**Consultation Response from KC,
Highways Development Management****2023/92215 land off, Woodside Lane, Fixby, Huddersfield, HD2 2HA****Outline applicaiton for erection of residential development****Date Responded: 30/11/2023.****Responding Officer: D. Stainsby****Responding Ref: K4-5NW/3**

This outline application is for one detached dwelling.

Drawing UD-488-01 Revision:

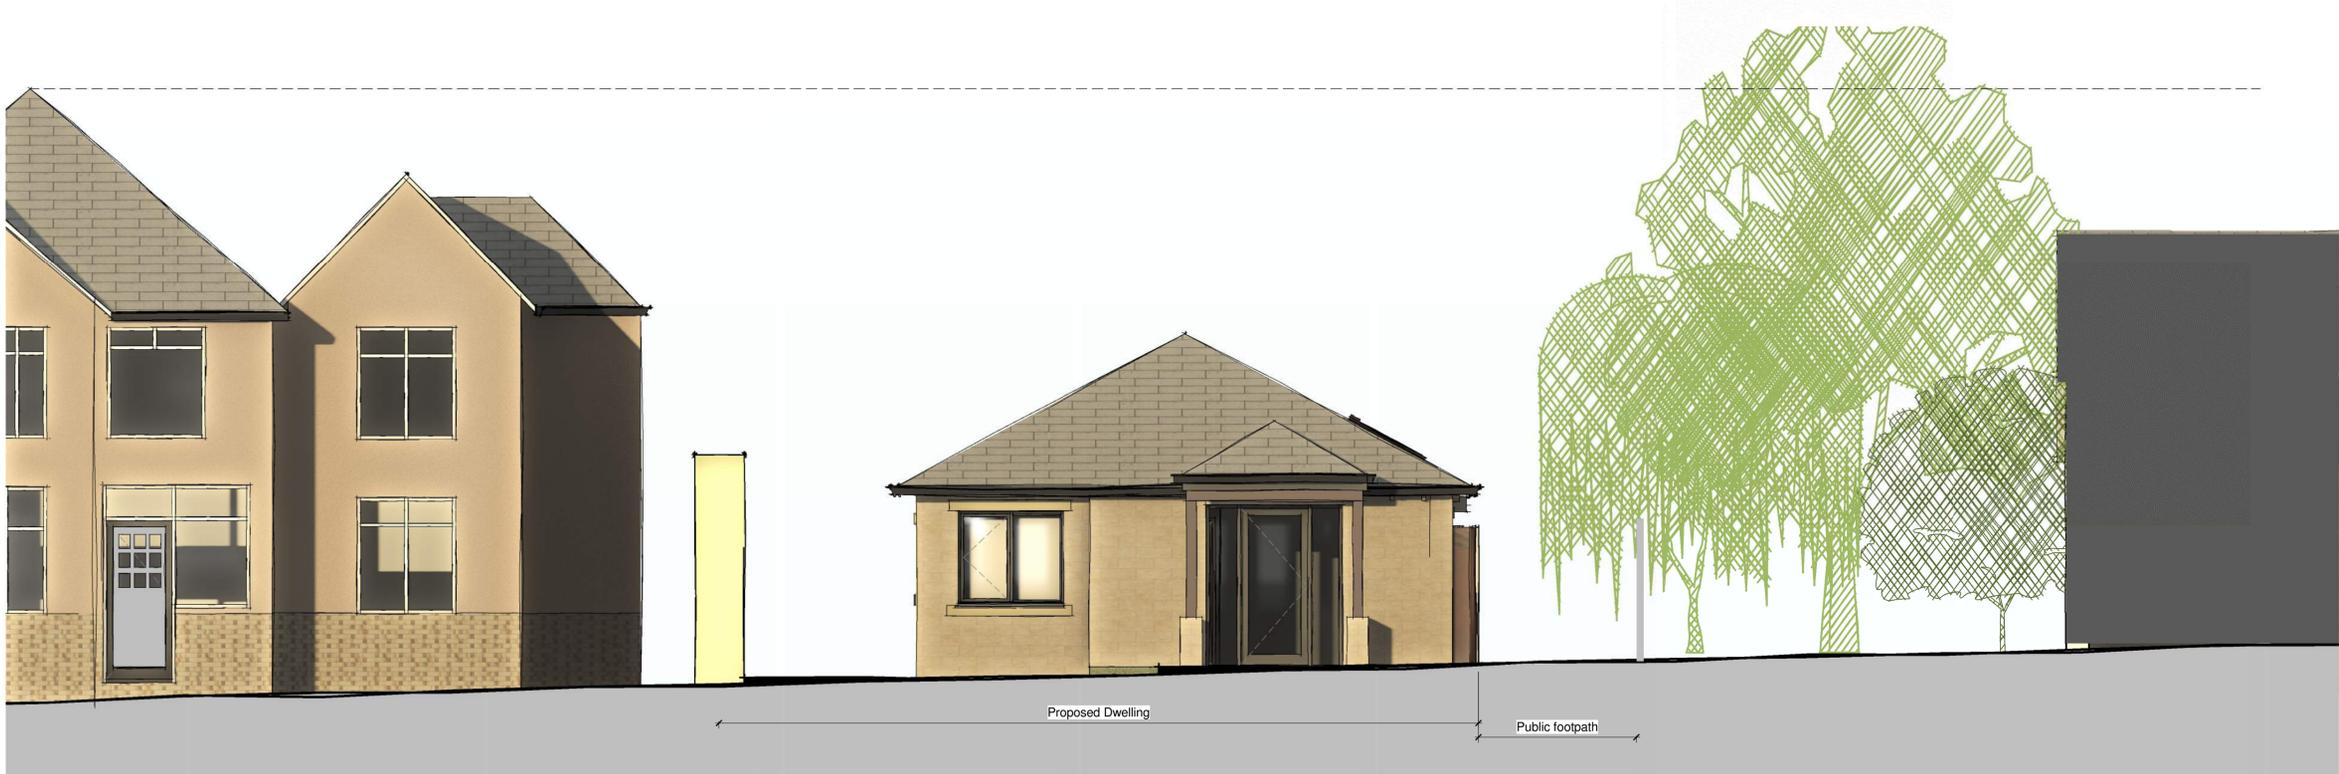
The proposed plans show a turning area for vehicles. However, this appears to be too small for vehicles to easily turn round without having to make numerous movements.

A revised layout showing the location of the proposed parking spaces and swept path analysis to show that the vehicles can carry out a simple three-point turn to leave the site in forward gear will be required.

Confirmation on the size of the proposed dwelling to confirm the number of parking spaces is required,

Details of waste storage and collection for the dwelling should be provided, with the location of a waste collection presentation point being clearly marked on a drawing in such a location that is easily accessible to the collection team and where it will not obstruct the parking, access, or the adopted highway for road safety reasons.
